Advice on Environmental Impact Statement – State Significant Development

Proposal: Residential Flat Building at 64-66 Lavender St & 3-7 Middlemiss St, Lavender Bay

Major Project reference: SSD-86797708

Attachment A – Detailed Environmental Heritage Advice

LAVENDER BAY
3-7 Middlemiss St
64-66 Lavender St
Drawing Name
COMPLIANCE DRAWINGS - SHADOW DIAGRAMS

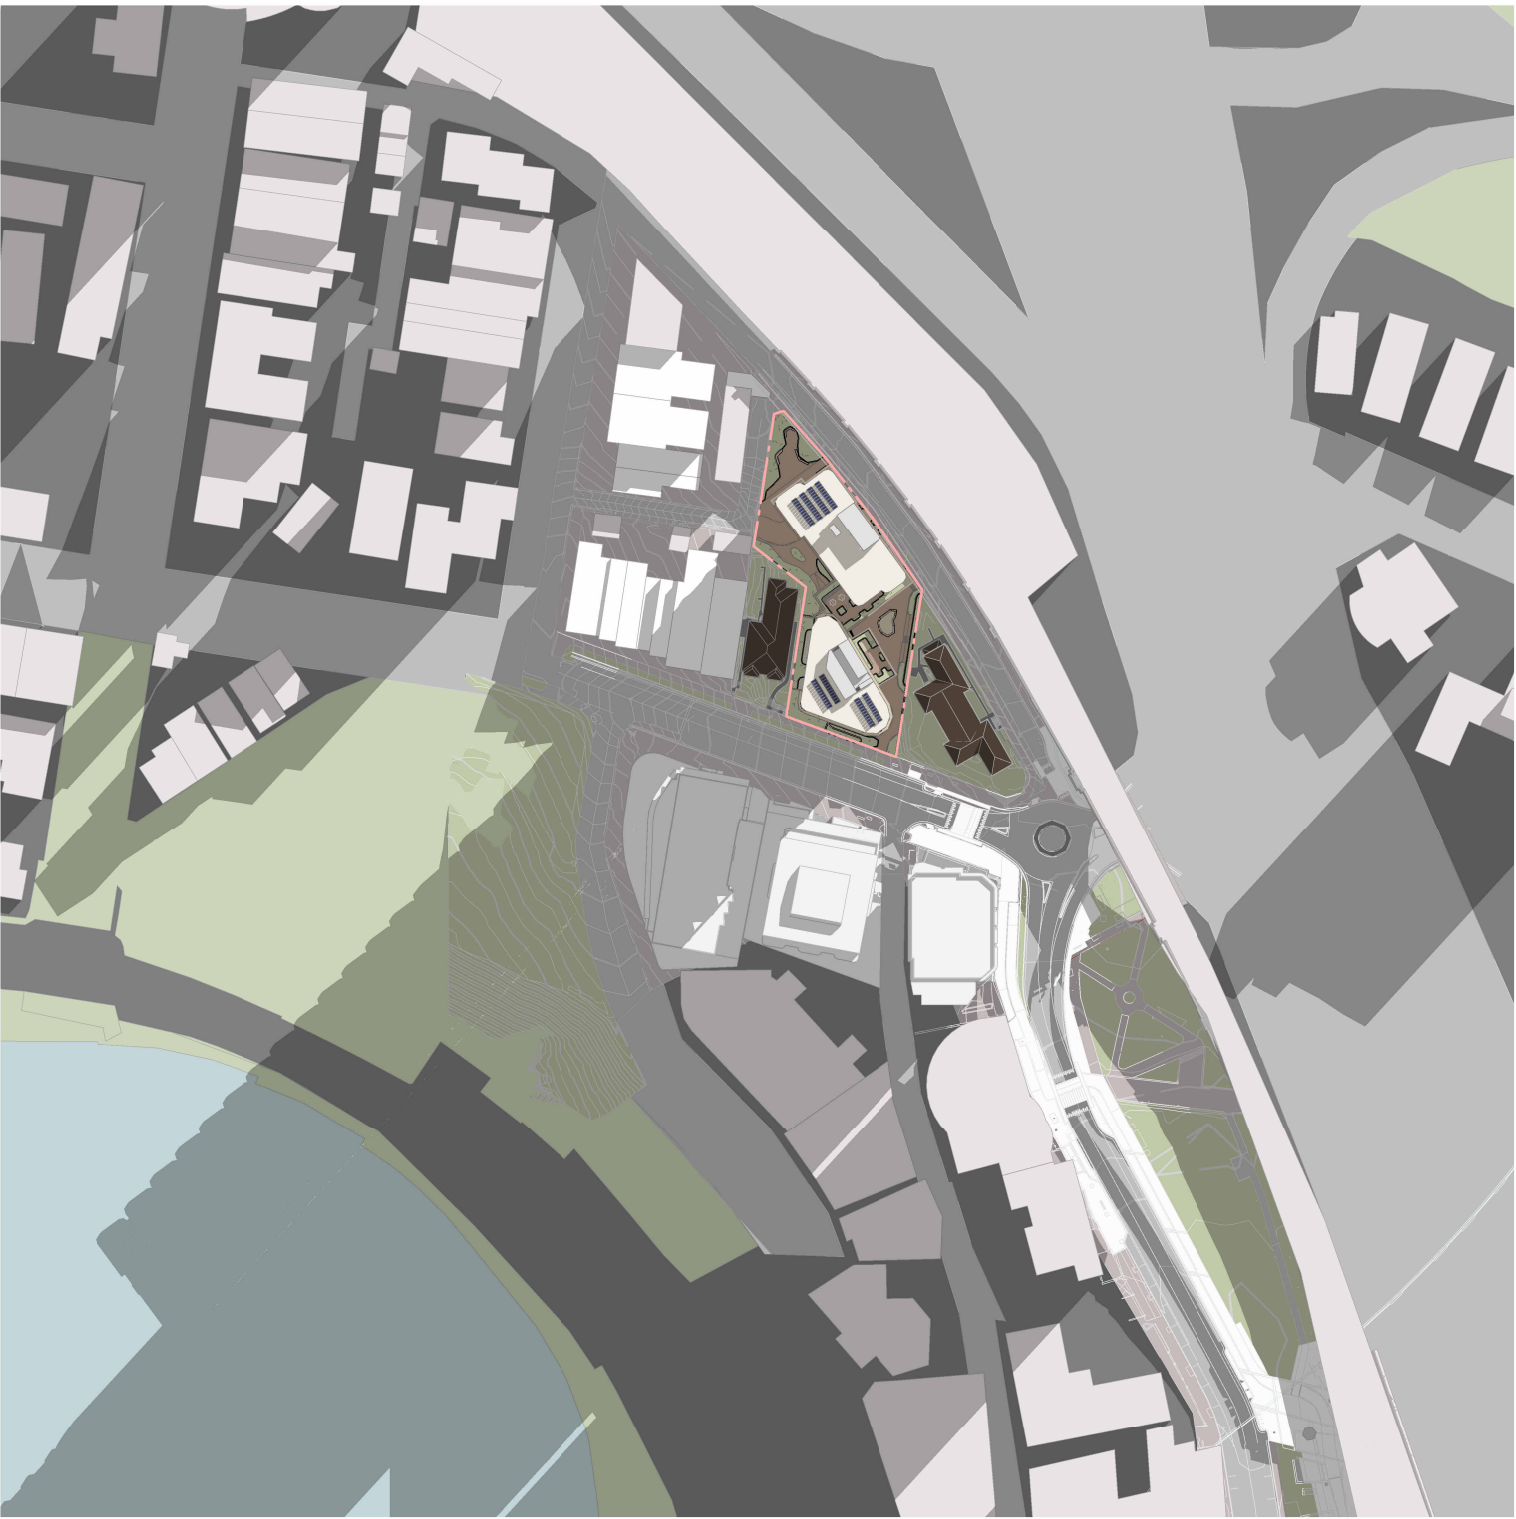
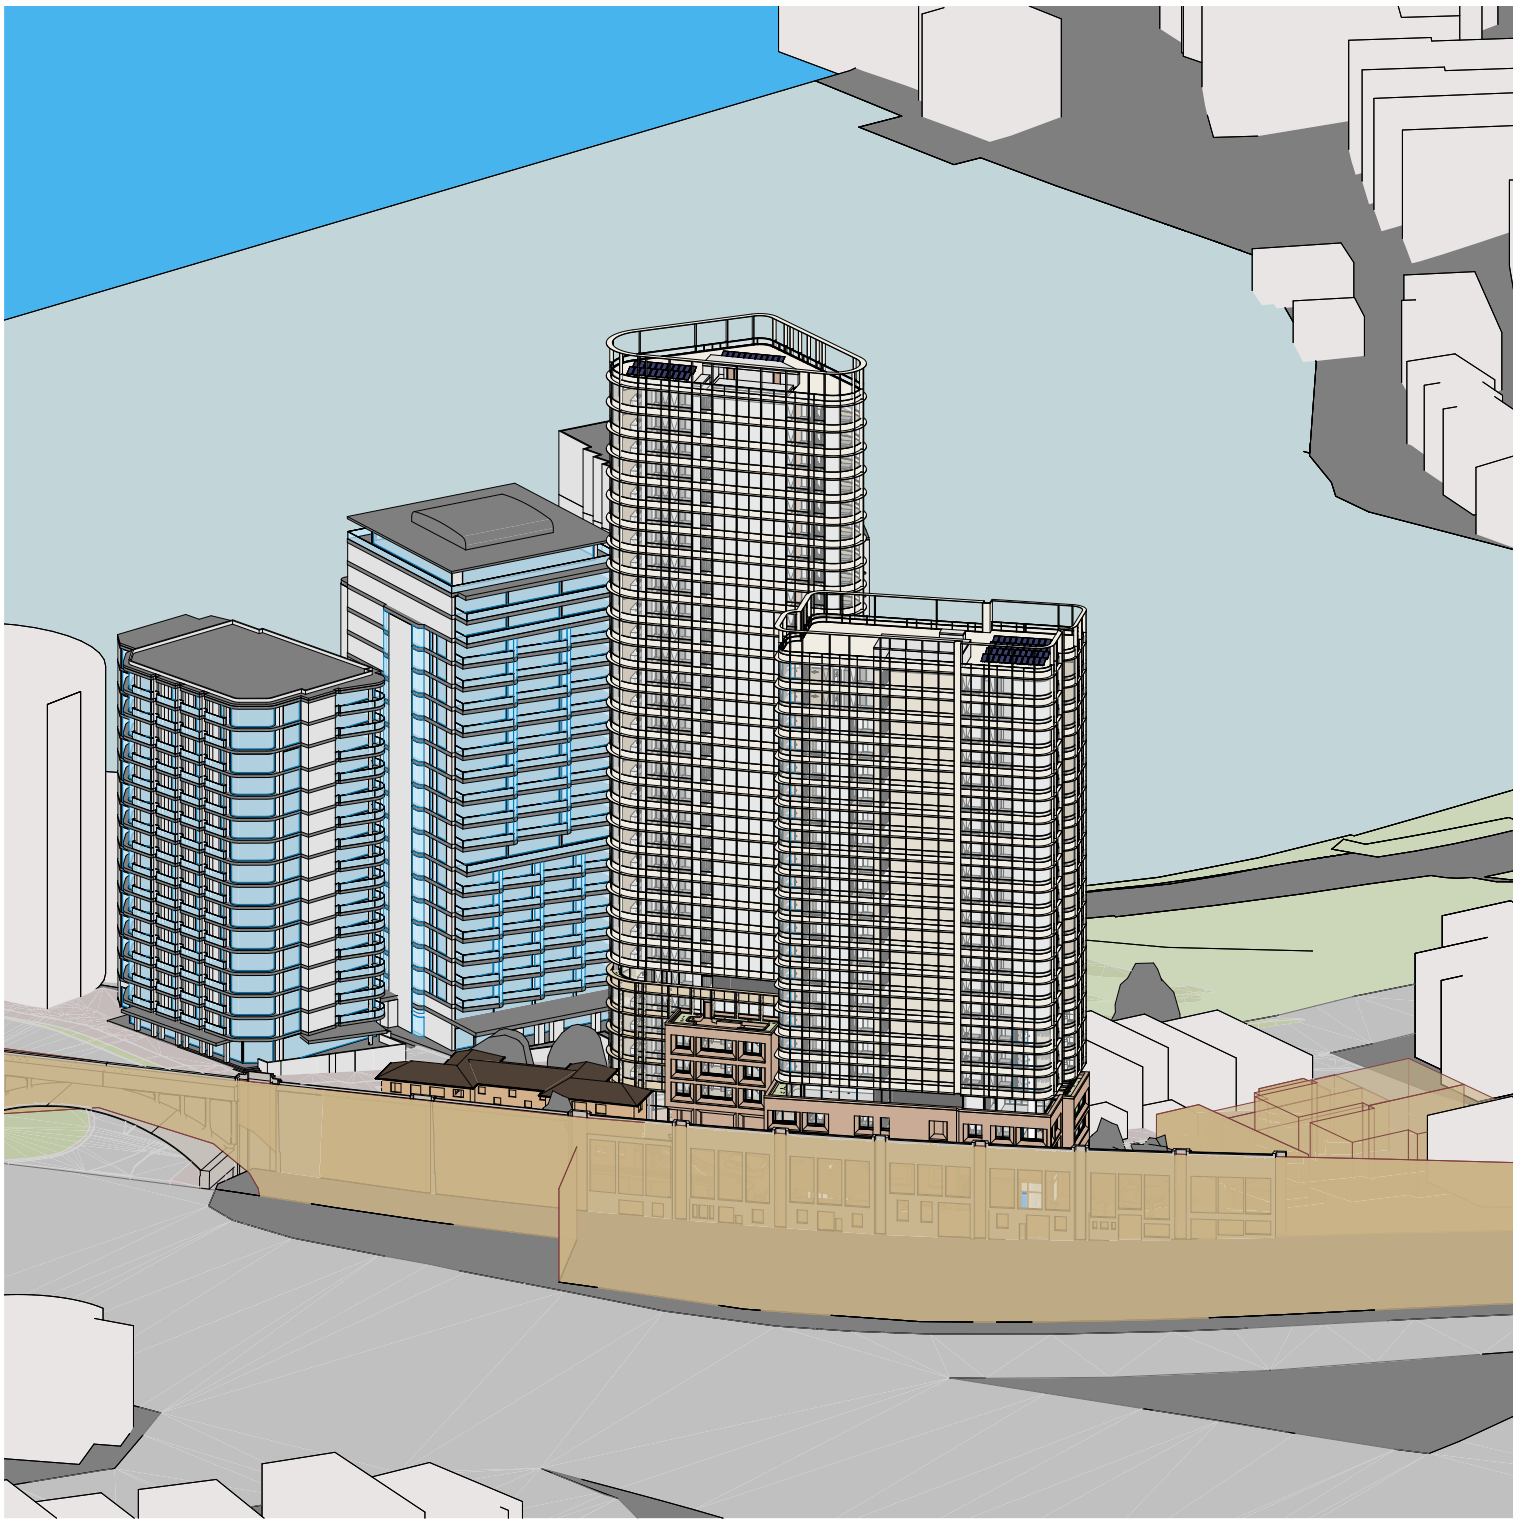
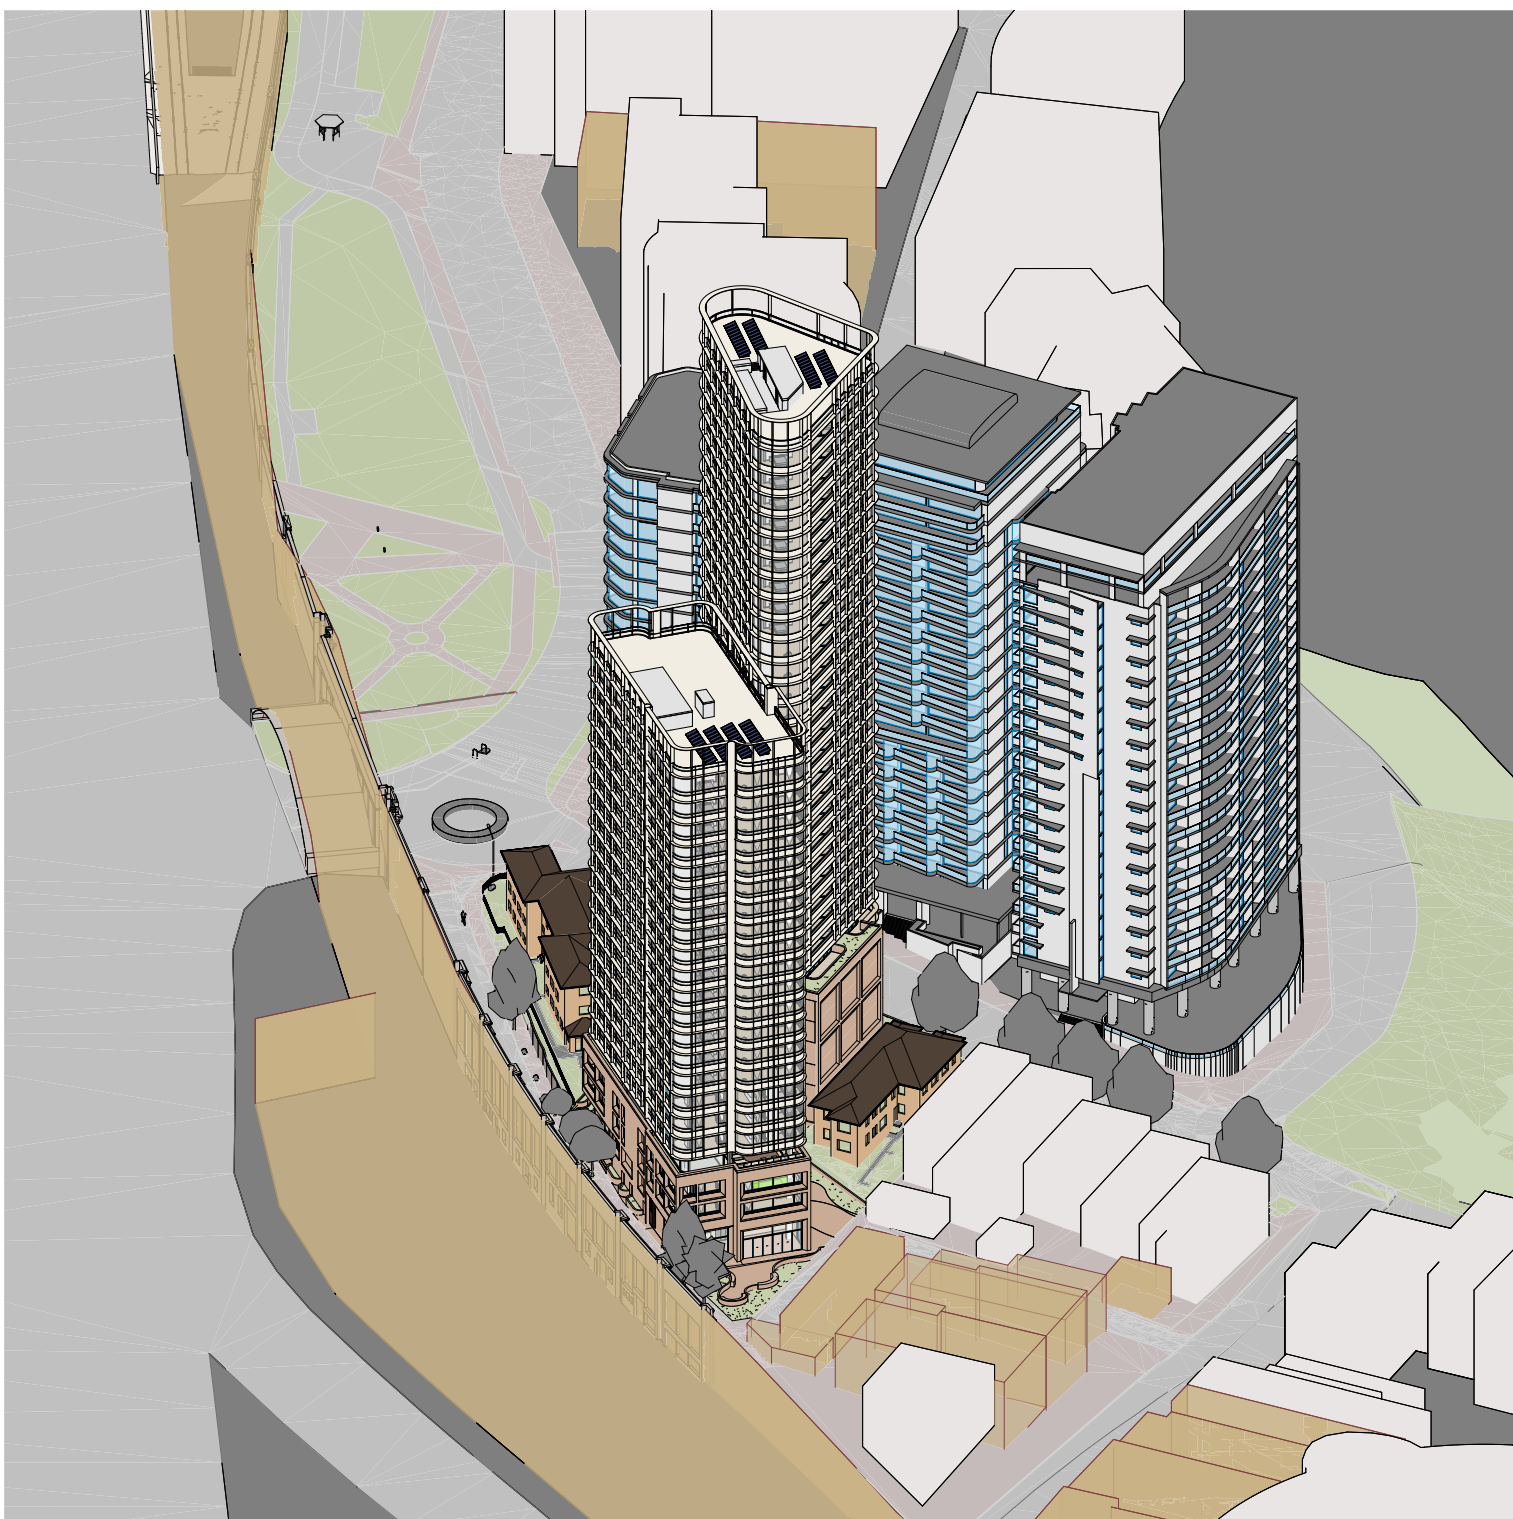
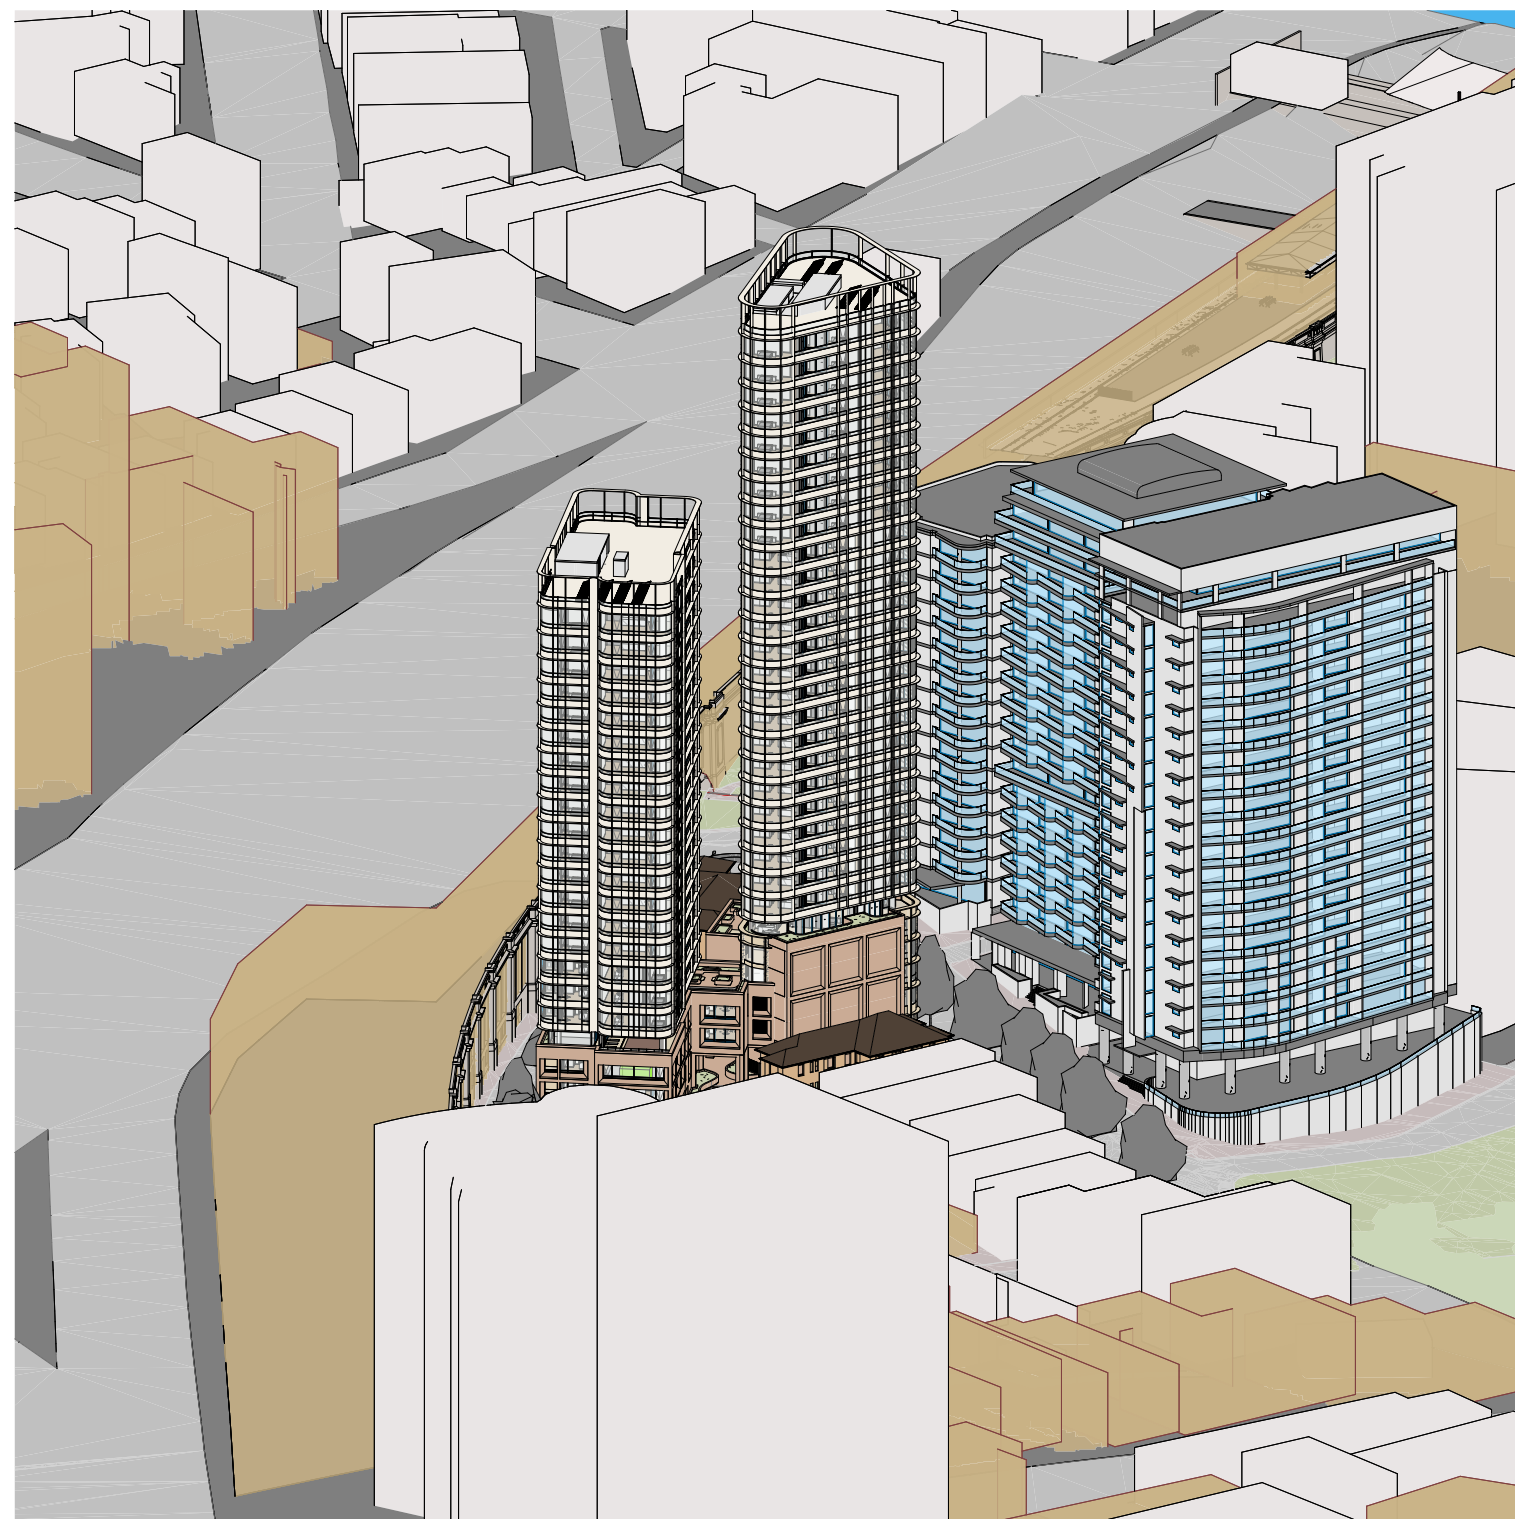
- Overshadowing: the shadow diagrams provided show that the SSD would result in additional overshadowing as follows:
 - Brett Whiteley House and Visual Curtilage (SHR 01949) would be impacted by substantial additional morning overshadowing in mid-winter. The additional shadows would impact Clark Park and Wendy's Garden as well as the waters and shoreline walkways of Lavender Bay.
 - There would be substantial afternoon overshadowing of parts of Bradfield Park (part of SHR 00781) in mid-winter.

We consider that the additional overshadowing would diminish the amenity of these parks and public areas and may adversely impact the health and condition of significant vegetation therein. We note that the curtilage for SHR 01949 encompasses both Brett Whiteley House and areas important to its setting and views as they were part of the inspiration for the considerable body of Brett Whiteley's art, including the Canary Island Date Palm trees in Clark Park. Additional overshadowing would adversely impact on the associated visual quality of these areas.

1. Additional shadow diagrams for all times of the year, before 9am and after 3pm as relevant.
2. Arboricultural advice regarding the impacts of additional overshadowing on vegetation in affected areas within Bradfield Park and the SHR curtilage of *Brett Whiteley House and Visual Curtilage*.
